Recommendation Report for Planning Permission for Works or Extension to a Dwelling

REF NO: BR/115/20/HH

LOCATION: 6 Highcroft Crescent
Bognor Regis
PO22 8DH

PROPOSAL: Single storey rear extension.

CLIENT: Mr & Mrs Szarowicz 6 Highcroft Crescent Bognor Regis PO22 8DH		
PROJECT: Rear Extension and alterations		
CHECKED: -	DRAWING NO: AZ-P-02	REV:
DATE: 17-05-20

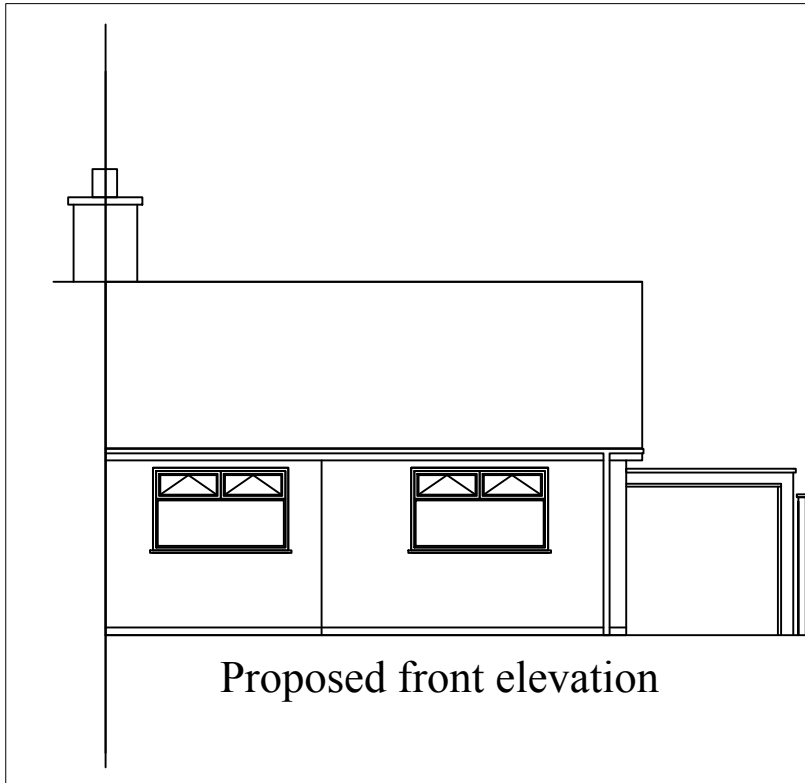
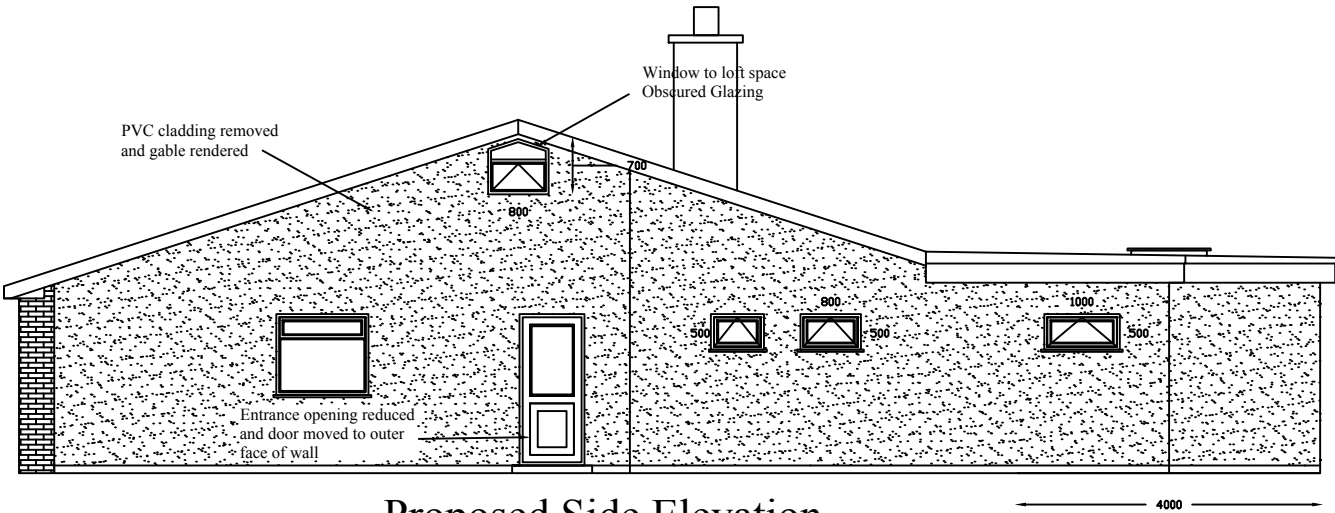
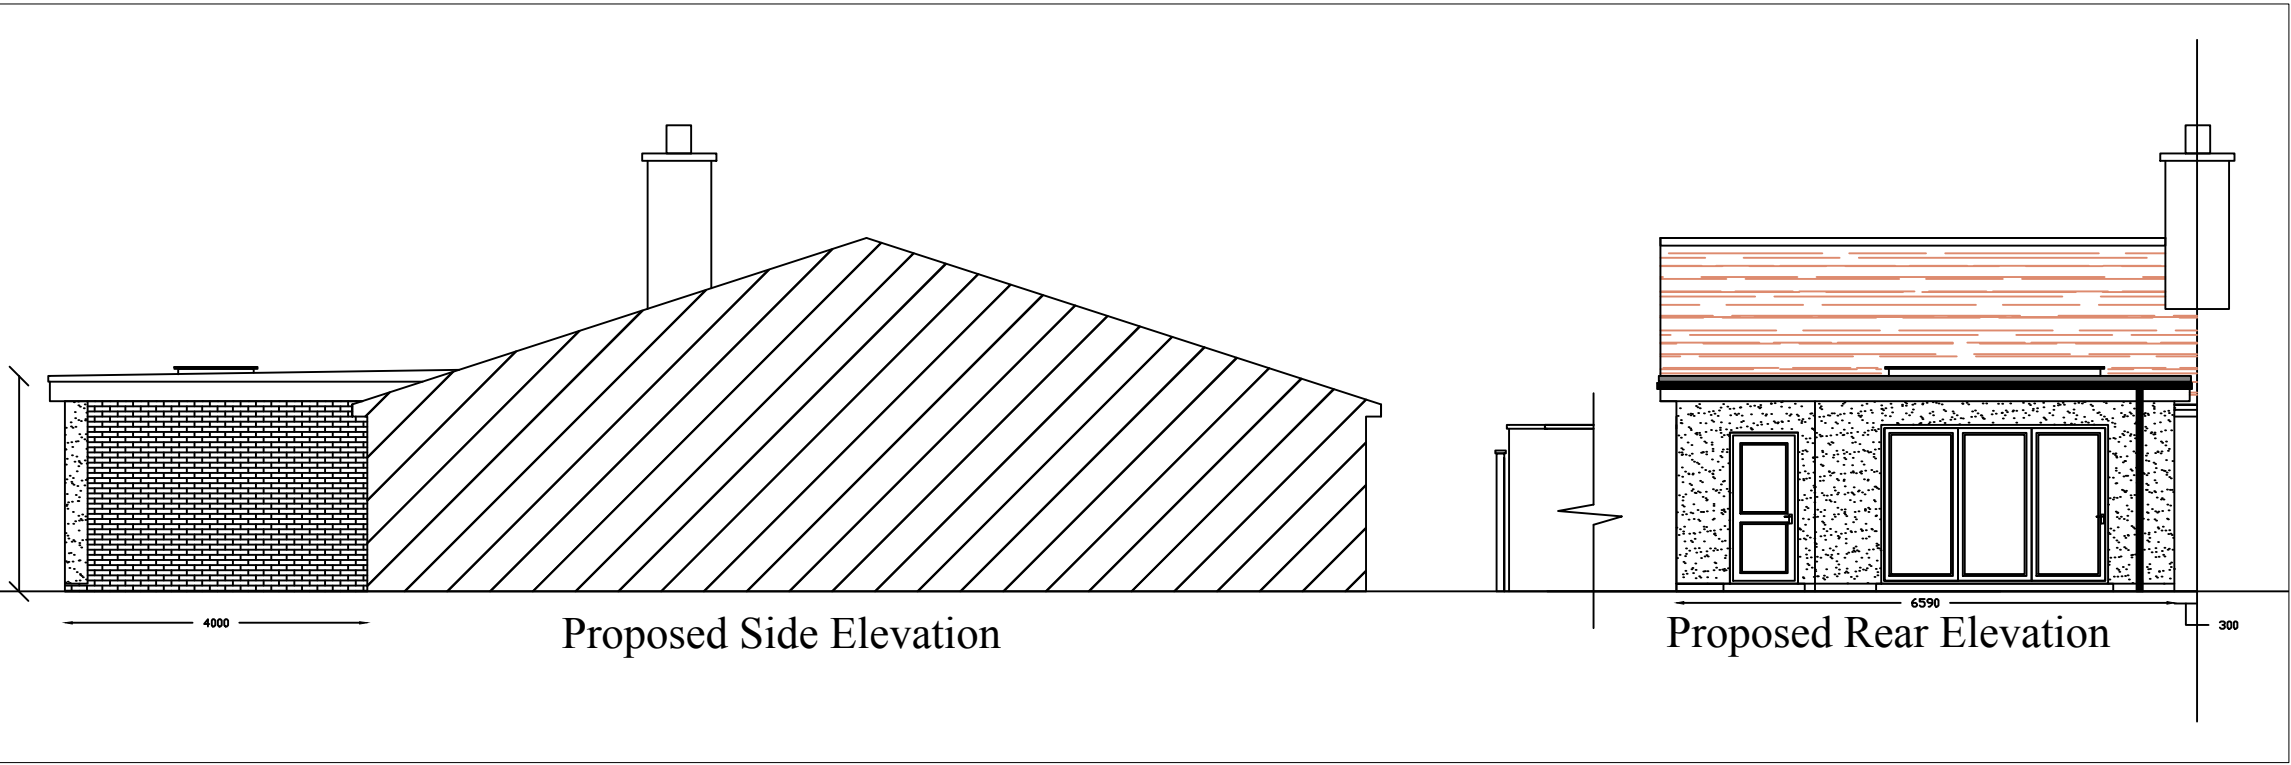
This extension will extend the full width of the rear and will have a flat roof with a height of 2.85m.

The neighbouring property has a conservatory running along the rear and the extension will extend 1m further in depth however there is a brick wall to the boundary and side elevation of the neighbouring conservatory which ensures the proposal does not give rise to adverse overbearing or overshadowing.

There will be doors to the rear however at single storey are not considered to give rise to adverse overlooking. To the southern side elevation there are 2 existing windows and these will be replaced with 3 smaller ones, however this is not considered to provide an adverse impact.

Floor Plan	Scale: 1-50 @ A3	CLIENT: Mr & Mrs Szarowicz 6 Highcroft Crescent Bognor Regis PO22 8DH		CHECKED:	DRAWING NO: AZ-P-03	REV:
		PROJECT: Rear Extension and alterations		DATE: 17-05-20

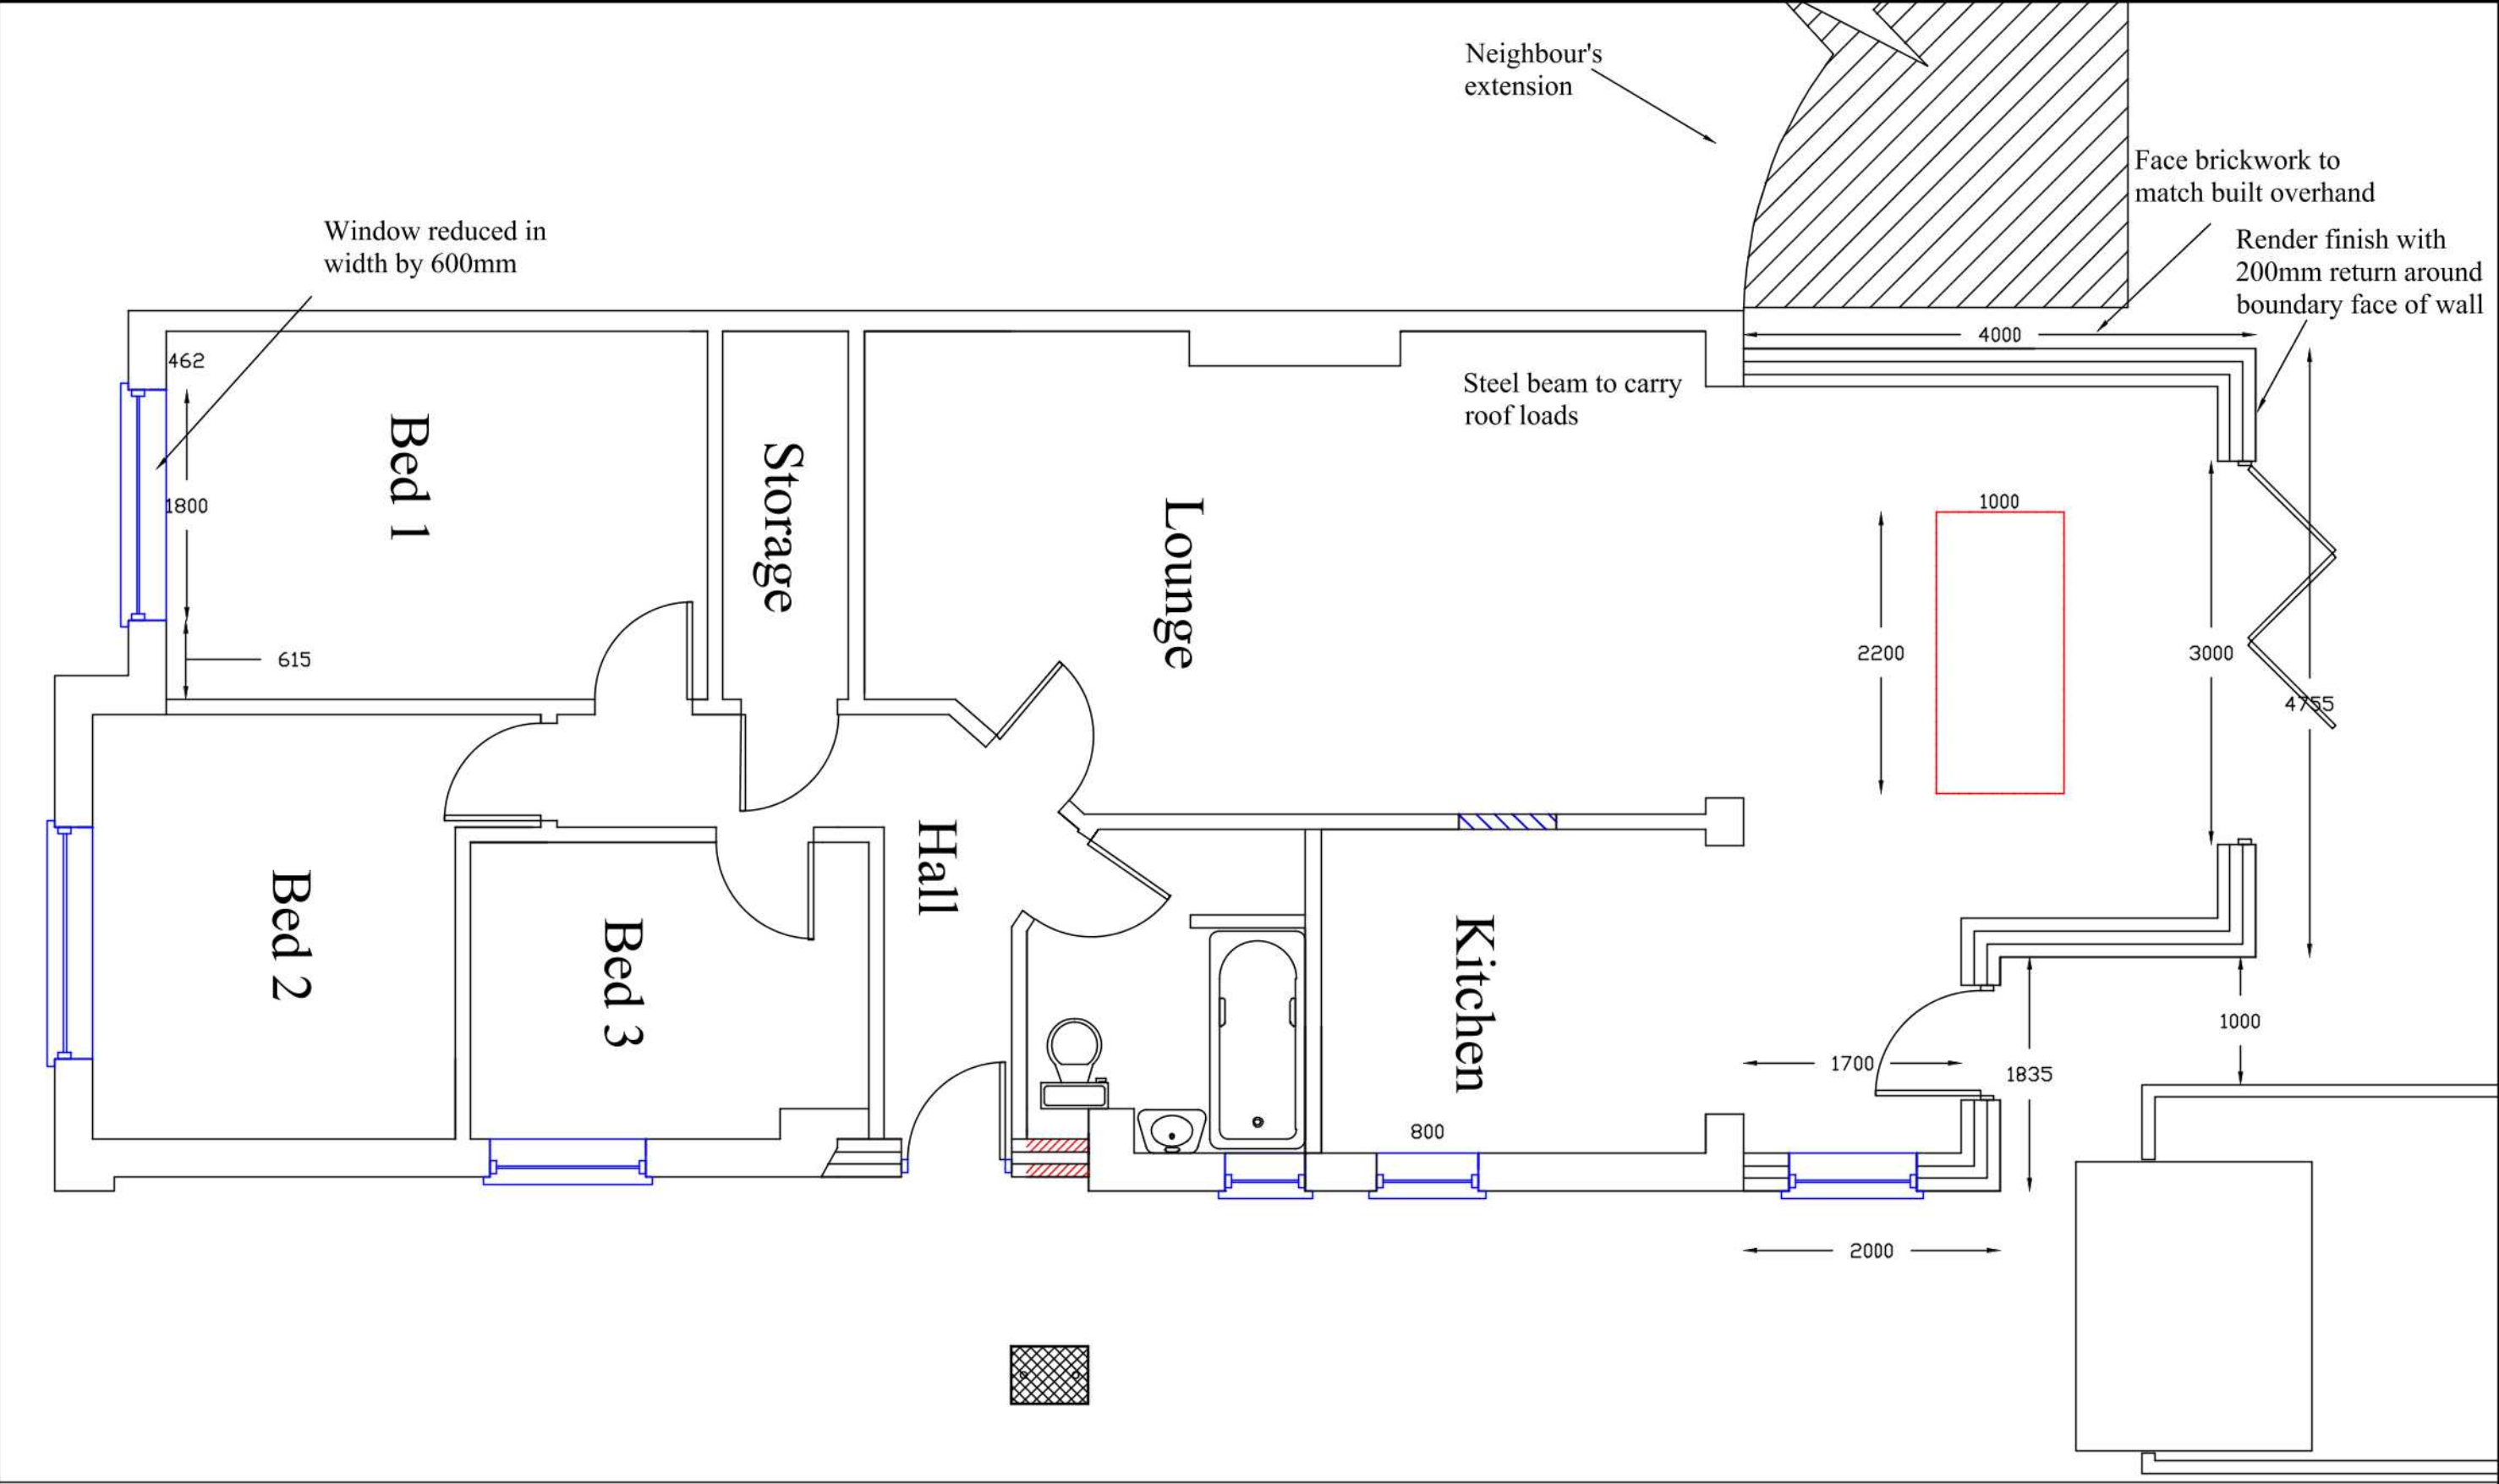
The extension will have a maximum depth of 4m which will reduce to 2m at the southern boundary in order for the existing garage to be retained.

There is 2.1m retained to the southern boundary which is considered sufficient to ensure there is no adverse impact to the southern elevation.
